DEVELOPMENT REVIEW BOARD
SUPPLEMENTAL SUBMITTAL

PROJECT NO. PR-2021-005459
Application No. SD-2021-00163 SI-2021-01248

**RE: PR-2021-005459 RESPONSE TO DRB COMMENTS
LOT 1A BLOCK 2 & LOT 2-A-1 BLOCK 2 SUNPORT PARK
2900 TRANSPORT ST NE**

The following items in this letter below provide the various adverse comments received from the Development Review Board plus responses for those comments as shown in bold for the approval request of Site Plan and Preliminary Plat.

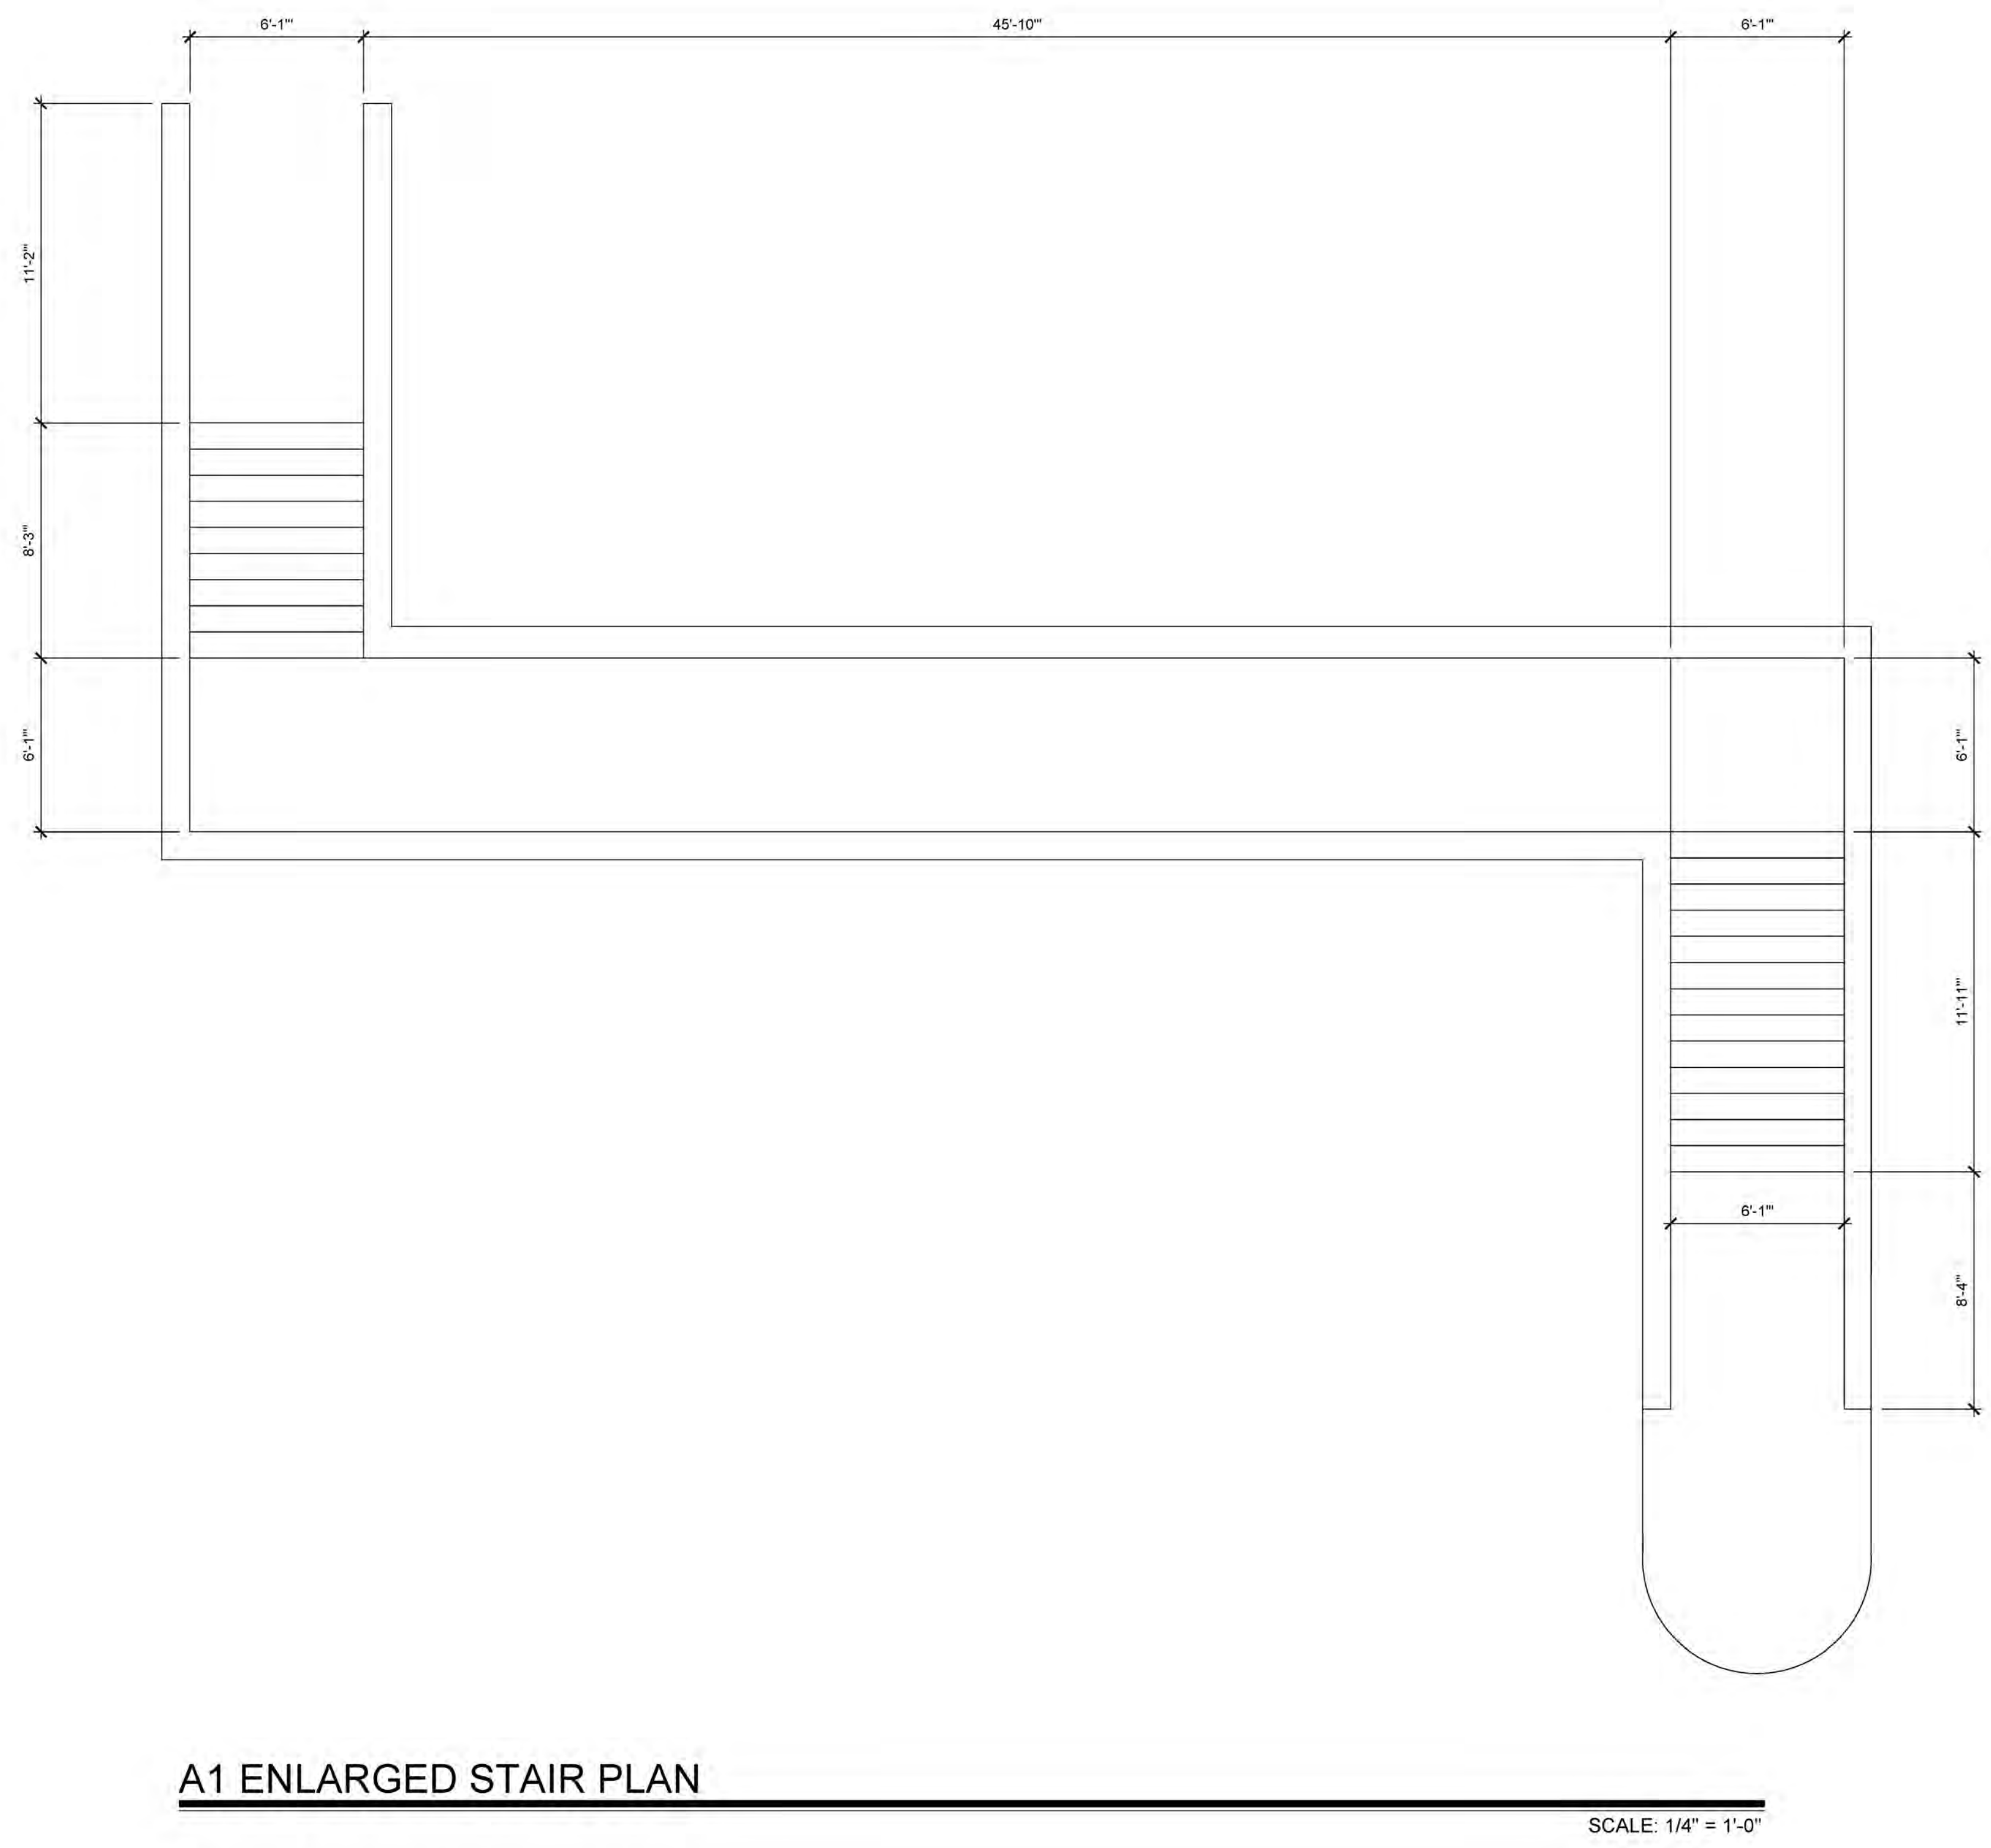
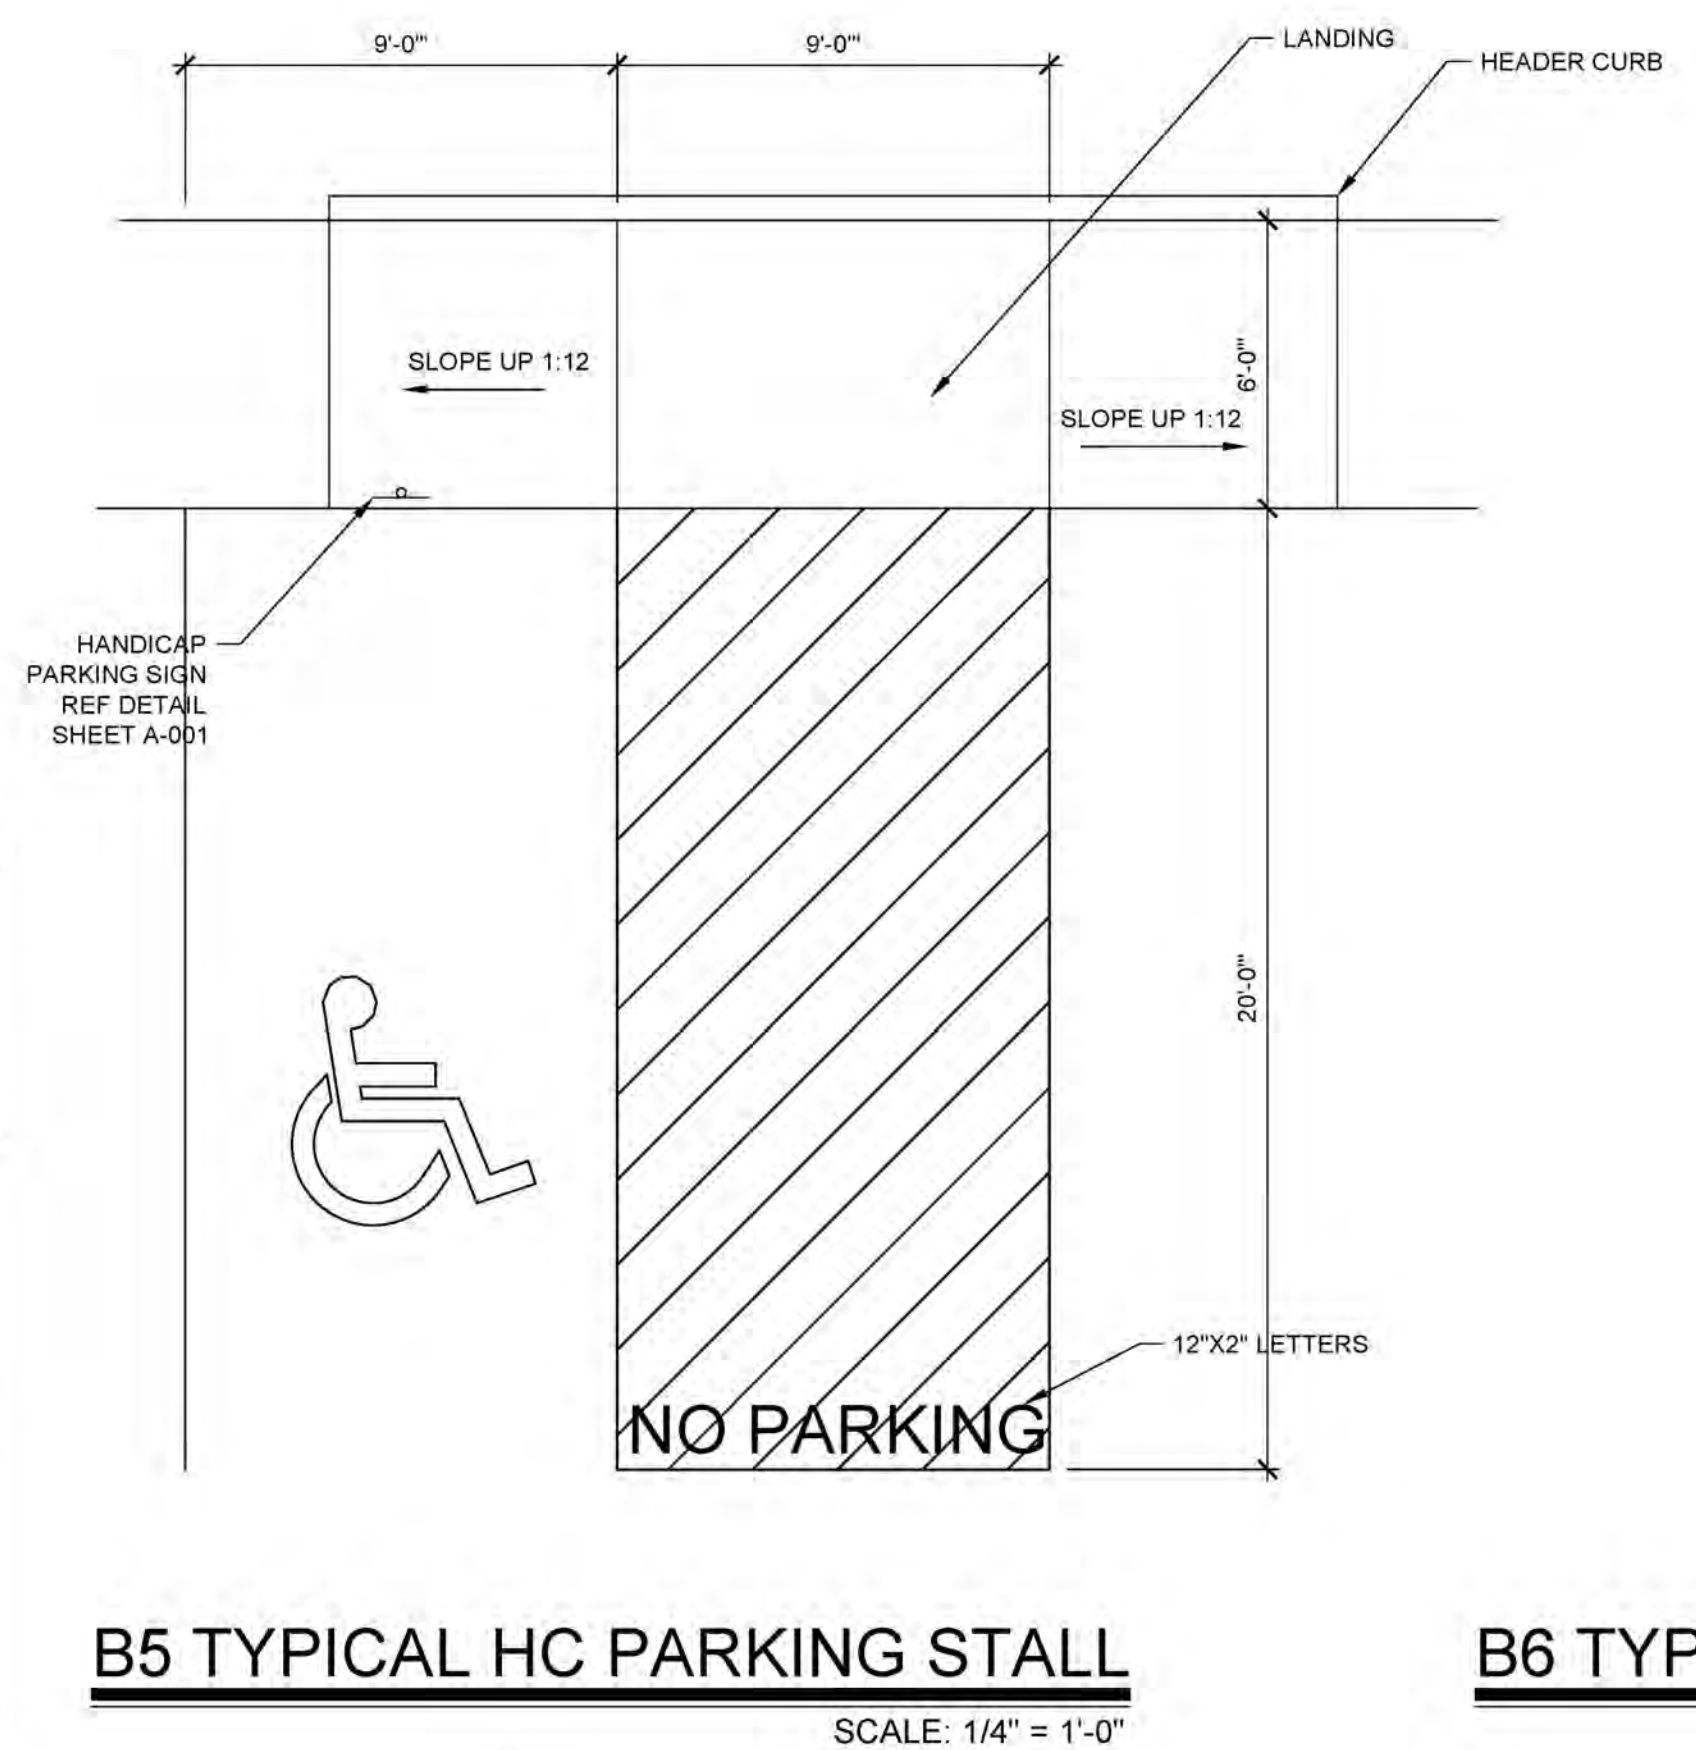
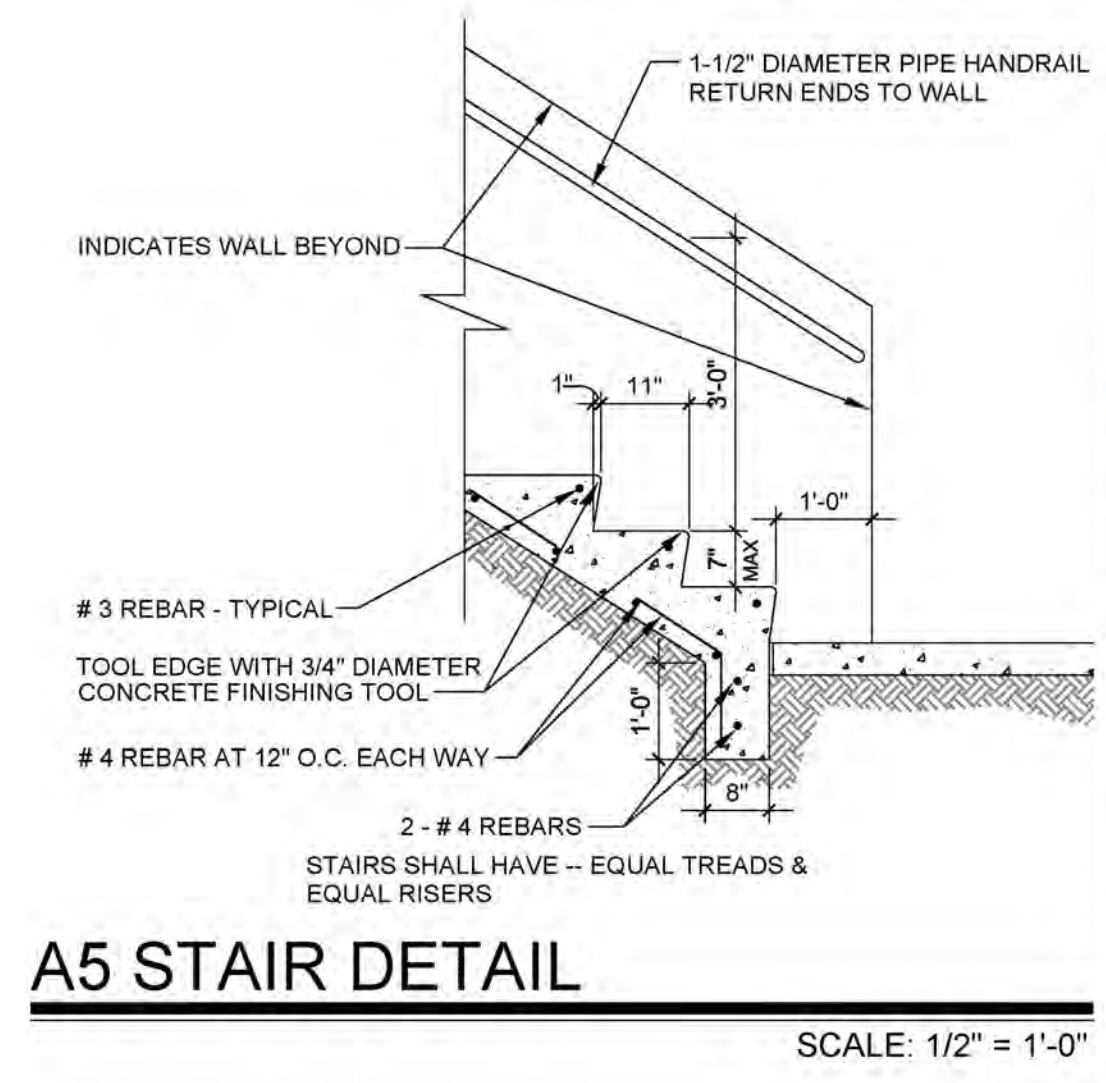
1. On the site plan, indicate the landscape buffer width between curb and sidewalk and/or provide a cross-sectional detail.
RESPONSE: 3'-6", reference revised keyed note U on A-001.

2. Include dimensioning for the motorcycle parking spaces, handicapped spaces, and van accessible aisles.
RESPONSE: Reference details sheet A-002.
3. Roadway dimensioning for the east access way is unclear. Because there are different dimensions for aisles, overall parking lot widths, and parking space lengths throughout the site, label typical dimensioning for each of the parking lot segments. (One of the dimensions for the access ways is shown in the thousands.) Shows curb radii near the Building 500 where the driving aisles make a 90-degree turn.

7. For curb ramp reference detail 2443, dimensioning of landing shall also be provided. It would be helpful to provide a detail showing handicapped spaces with the van accessible aisles since this is pretty typical.

8. An incorrect curb ramp detail reference is made on Keyed Note W. Make sure all ramps on-site are called out. Call out all ramps on the plan at the van accessible aisles, crosswalk aisles, etc. Make sure that the crosswalks line up with the sidewalks.

RESPONSE: Additional dimensions provided.
4. Regarding the detail for the stairway to the western right-of-way, include details for the entire layout including the number of steps, dimensions of landings, slopes along the straight sections, etc.

RESPONSE: Detail added to A-002.
5. Dimension parking lot keyway by Club House 800.
RESPONSE: Dimension added.
6. Clarify if turn-down sidewalk edge will be built along the parking lot or if header curb is adjacent to the sidewalk.

RESPONSE: Turn down sidewalk will be used reference revised keyed note K.

RESPONSE: Reference detail B5 / A-002

RESPONSE: Reference change, see keyed note W. Crosswalk alignment corrected west of building 500.
